# A47 Wansford to Sutton Dualling

**Scheme Number: TR010039**

## **Volume 9** **9.16 Applicant's Response to Written** **Representations**

**9.16 APPLICANT'S RESPONSE TO WRITTEN  
REPRESENTATIONS**

Figure 7 – The Scheduled Monument magnetometer survey by Headland Archaeology on behalf of Highways England

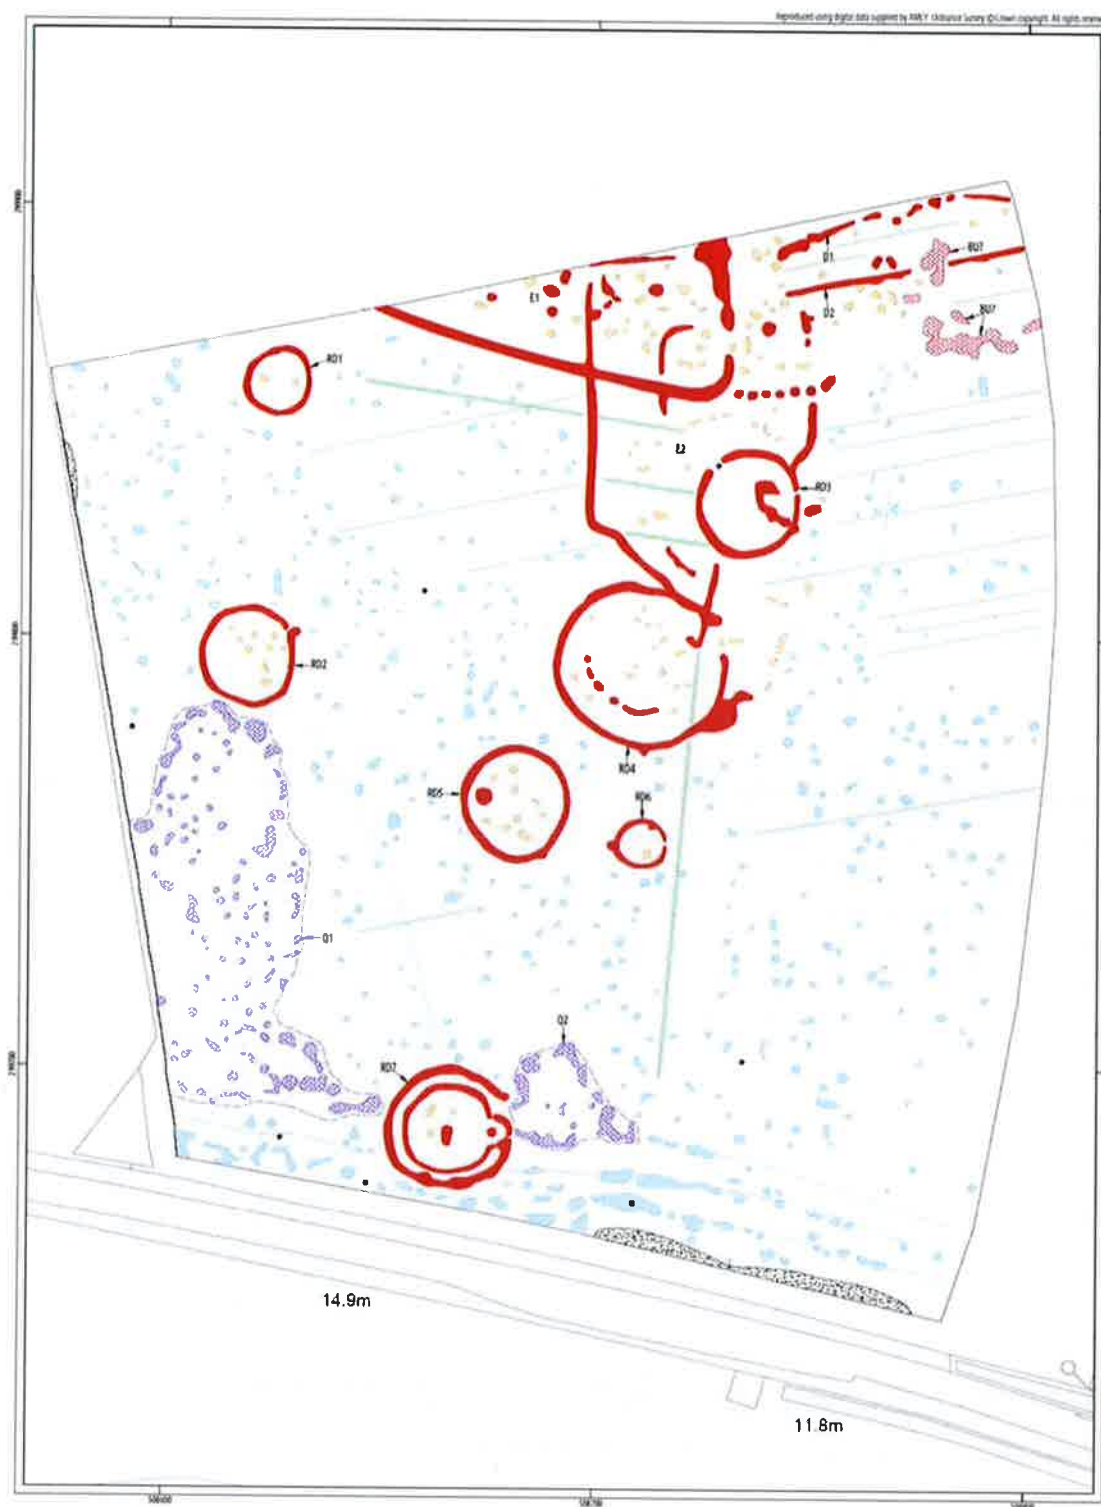
Reference	Written Representation	Applicant's Response
	<p>approved in exceptional circumstances. This essentially sets up two tests, whether the damage is substantial and whether the circumstances are exceptional.</p> <p>The route that is proposed avoids all the identified features of the Scheduled Monument except for an area of quarrying that is almost certainly related to the construction of the existing A47. It therefore does not do substantial damage to the Scheduled Monument. Before construction, the 25m wide path required for the new road should be surveyed using alternative non-invasive techniques such as ground penetrating radar and any features found can be excavated. Because the available corridor between the identified features is considerably wider than the road, there is scope to modify the alignment if something major is found.</p>	<p>geophysical survey for this type of monument and land form: Resistivity would be potentially better for identifying fine detail of solid structures such as walls, which are not indicated by the magnetic results.</p> <p>Ground penetrating radar would indicate the depth of buried surfaces and features. This may be useful for the development of conservation management plans for the monument in the long term but is not relevant to the Scheme.</p> <p>Micro-seismic and micro-gravity survey would aid in the identification of voids, such as backfilled quarries and larger burial chambers. Unfortunately, the A47 would have to be entirely shut down to enable these surveys due to the sensitivity of the equipment and interference from moving vehicles. Additionally, microgravity survey generally does not give a resolution that would be useful for this asset and micro-seismic survey is generally more suited to discrete sites such as burial mounds and fougous rather than more diffuse sites like this.</p>

<p>The features of the Scheduled Monument are discussed in some detail in a Wansford Parish Council document entitled The Alignment of the A47 Dualling Between the Wansford Eastern Roundabout and the Old Railway</p> <p>The minutes of the direct meeting between NH and Historic England show that NH never seriously proposed the option of going through the SM, presenting it just as a proposal by a third party with no ownership by NH.</p> <p>As the project developed there were a series of meetings between NH, Peterborough City Council (PCC) and Historic England to discuss the various environmental and archaeological aspects of the scheme.</p>	<p>The Applicant has consulted with Wansford Parish Council, both informally and formally throughout the development of the Scheme. Details of consultation are set out in the Consultation Report (<b>APP-023</b>) and its Annexes (<b>APP-024 – APP-038</b>).</p>

Figure 9 – The A47 Routed over the Southern Barrow

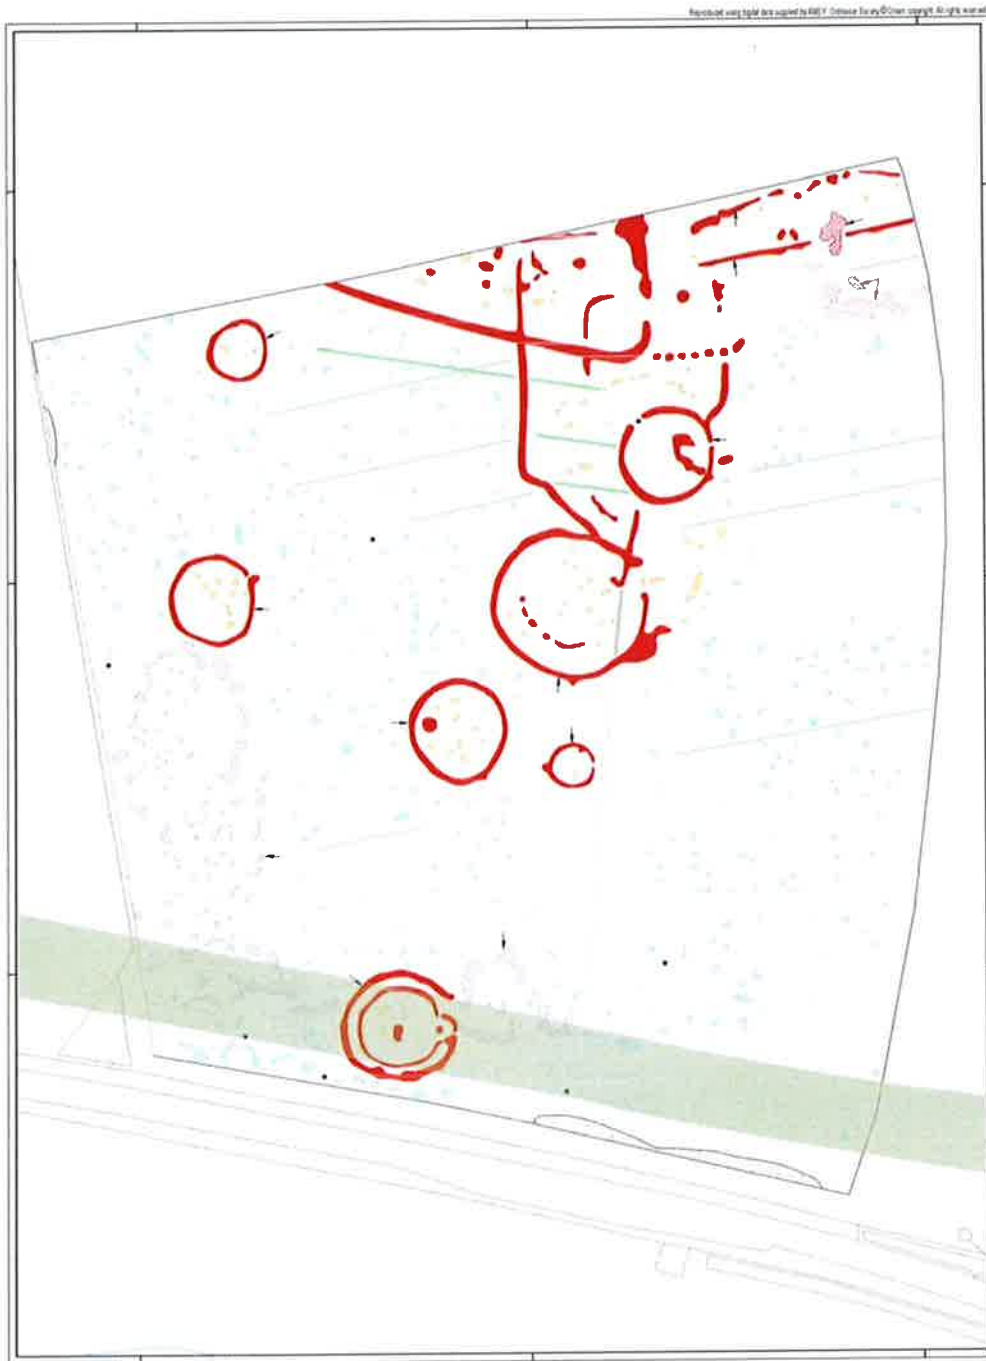
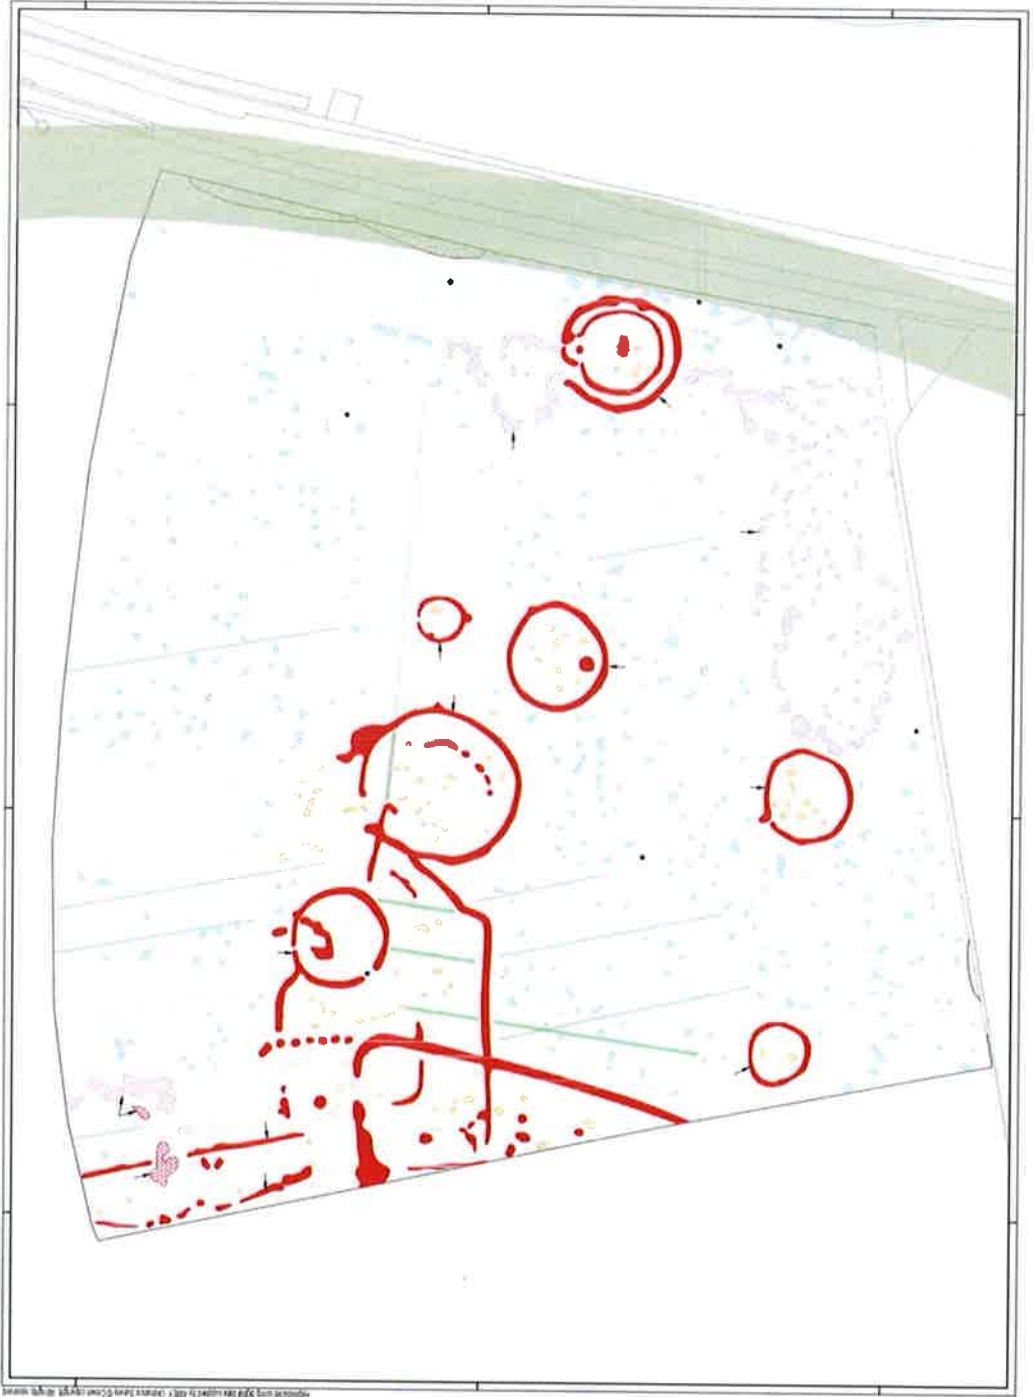
<p>3 3.1</p>	<p><b>3 Discussion of Routes Through the Scheduled Monument</b>  <b>3.1 National Highways</b></p> <p>Even though the route shown in Figure 1 was offered by National Highways in their initial consultation, they have consistently said that they cannot impinge on the SM because there is a viable alternative and therefore there is no Exceptional Circumstance to justify touching the SM. They have also claimed that they cannot challenge Historic England on this "because it is not their role to challenge another government department".</p> <p>The reality is that NH seem to have misunderstood the criteria for impinging on a Scheduled Monument.</p> <p>The position of a Scheduled Monument within the context of a Development Consent Order application for a national infrastructure project is governed by the National Policy Statement for National Networks (NPSNN) (Dept. of Transport, December 2014). This document states that projects doing substantial damage to a Scheduled Monument will only be</p>	<p>Known features of the Scheduled Monument have been identified to date through aerial photography, magnetometry and surface artefact collection. No intrusive works have been undertaken to verify these sources. In the results of the intrusive works undertaken for the Scheme, a significant number of features were identified in trenching that had not been previously indicated, including burials. This suggests that the area indicated has the potential to contain as-yet unidentified features.</p> <p>Additionally, if the indicated area is truly devoid of archaeological features, this itself would be an important part of how the Scheduled Monument is understood. Use of negative space and partitions between features may provide context and information on the use and conceptualization of those features.</p> <p>Bifurcation of the Scheduled Monument would result in substantial harm in either eventuality.</p> <p>The use of magnetometry is the most appropriate form of</p>
